DRB Application No.: 07DRB-70106 (P&F)
Project Name: LANDS OF TEODORA PADILLA
Agent: JACK'S HIGH COUNTRY INC

RE: Tract M-6, Lands of Teodora Padilla/p&f

DEVELOPMENT REVIEW BOARD
TRANSPORTATION DEVELOPMENT
Standard Comment Sheet

PLAT OF TRACTS M-6-A AND M-6-B LANDS OF TEODORO PADILLA

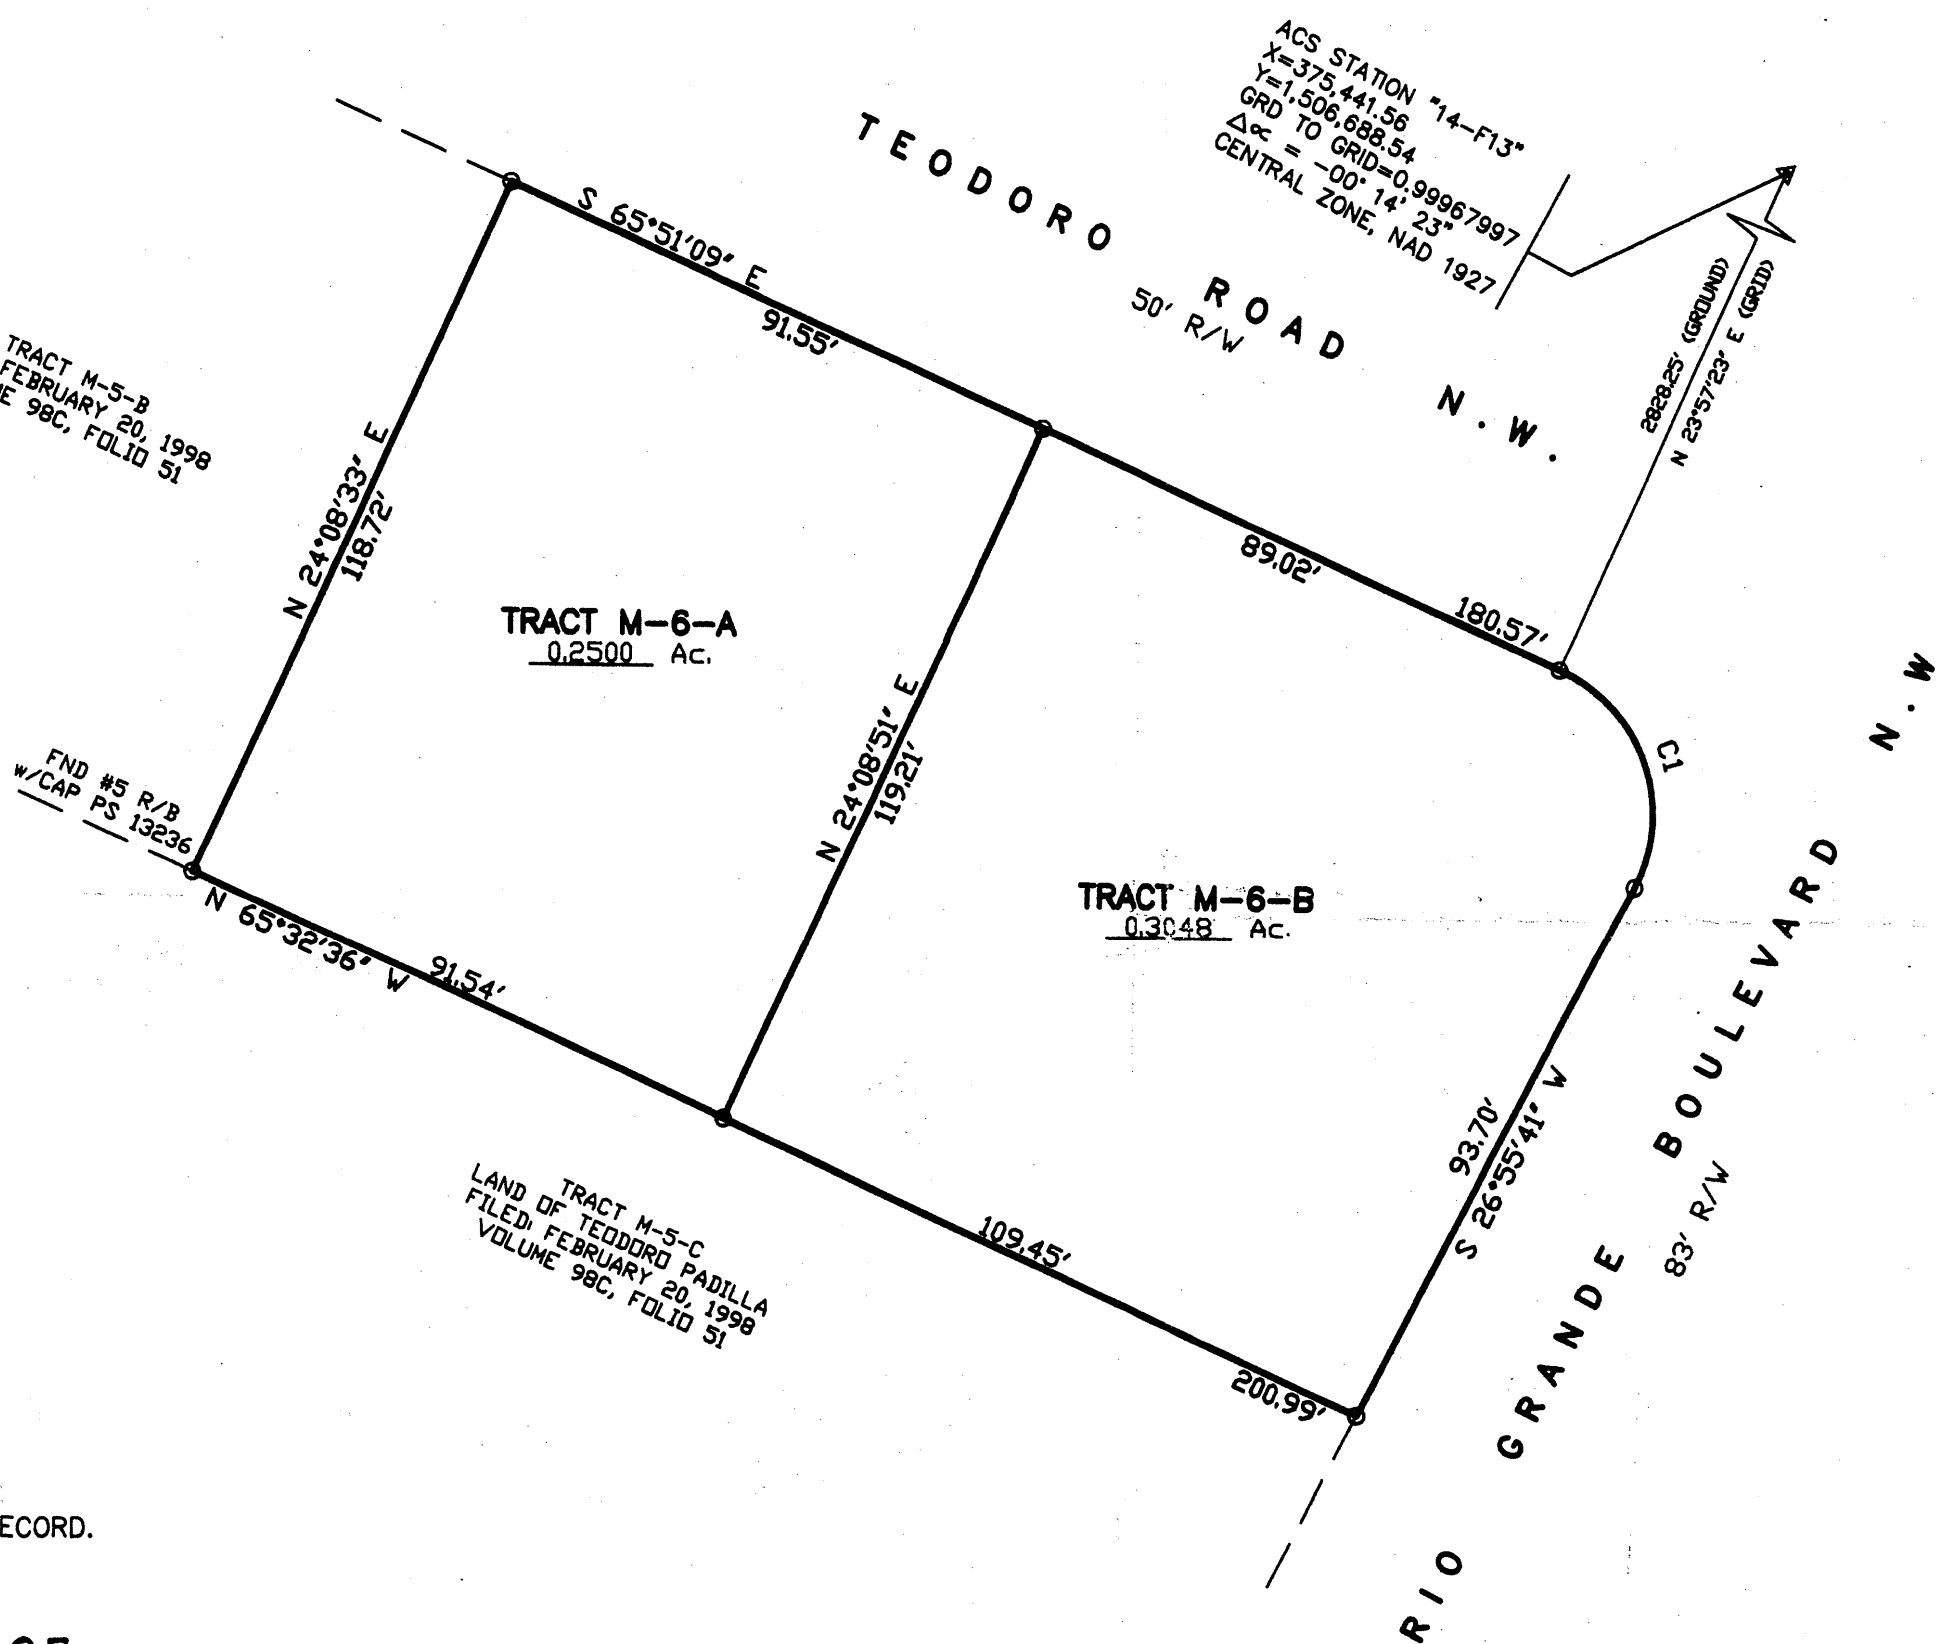
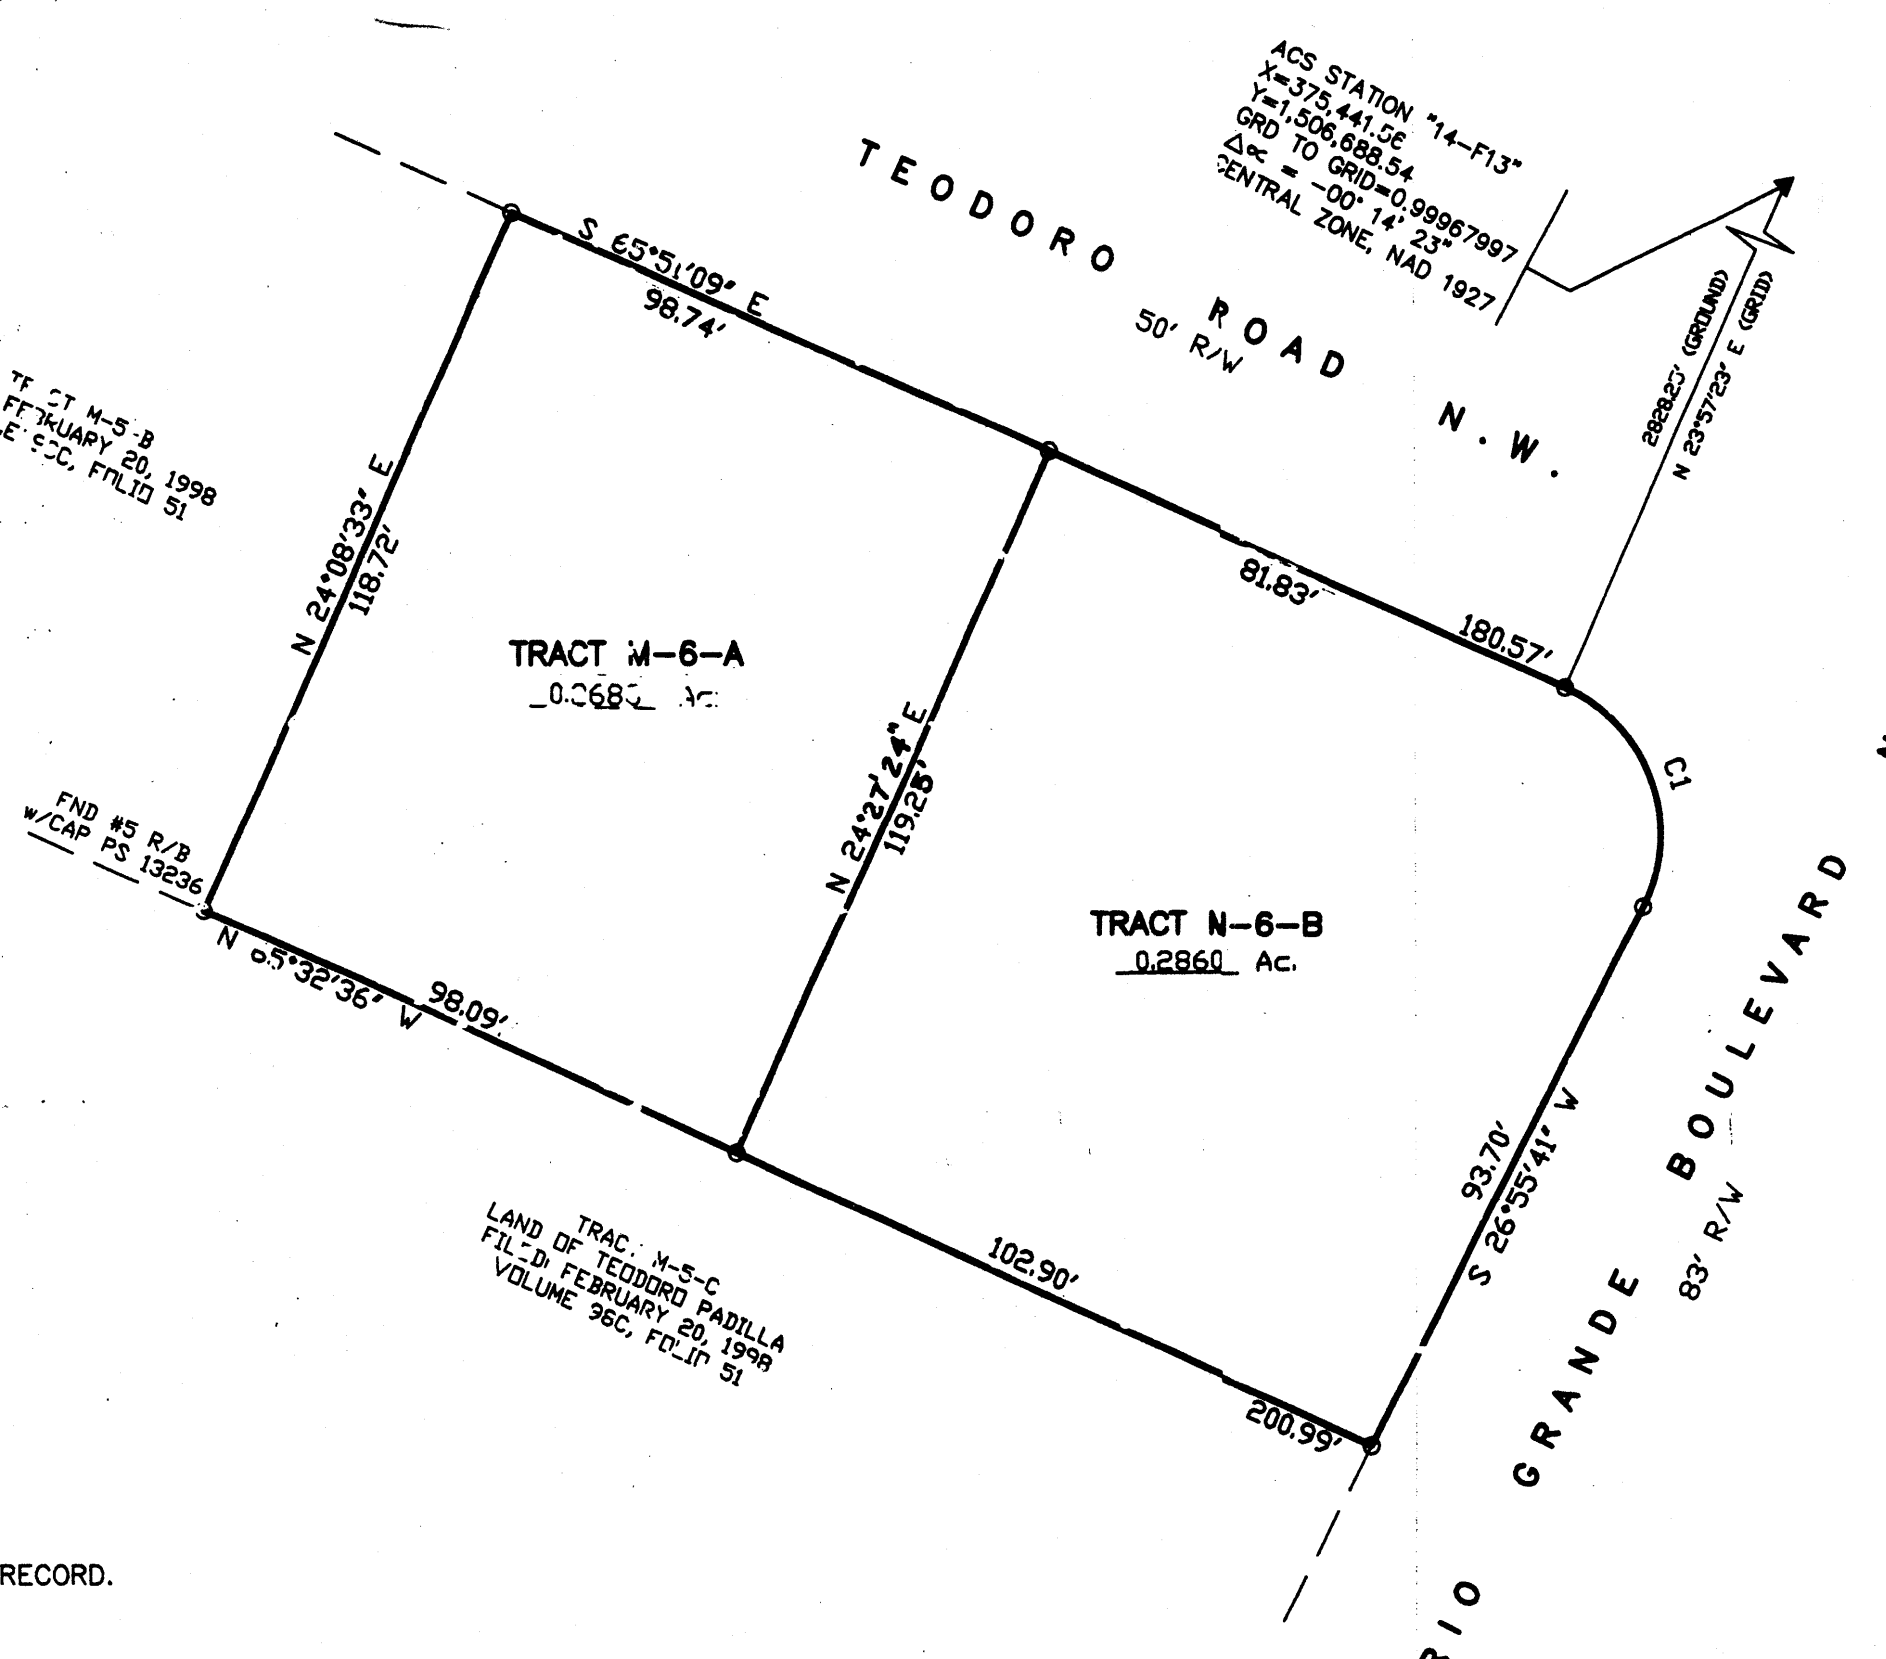
- 1) Rio Grande requires 86' of r/w.
- 2) Why is there no curb/gutter or sidewalk along Teodoro?
 Is this a private road?
- 3) Infrastructure will be required.

HE IS APPROVING OF THE MANNER AND METHOD, BY WHICH WE ARE ADDRESSING HIS CONCERNS. WE RESPECTFULLY REQUEST THAT OUR DRB CASE-PROJECT NUMBER 1006596 BE RETURNED TO THE NEXT POSSIBLE AGENDA.
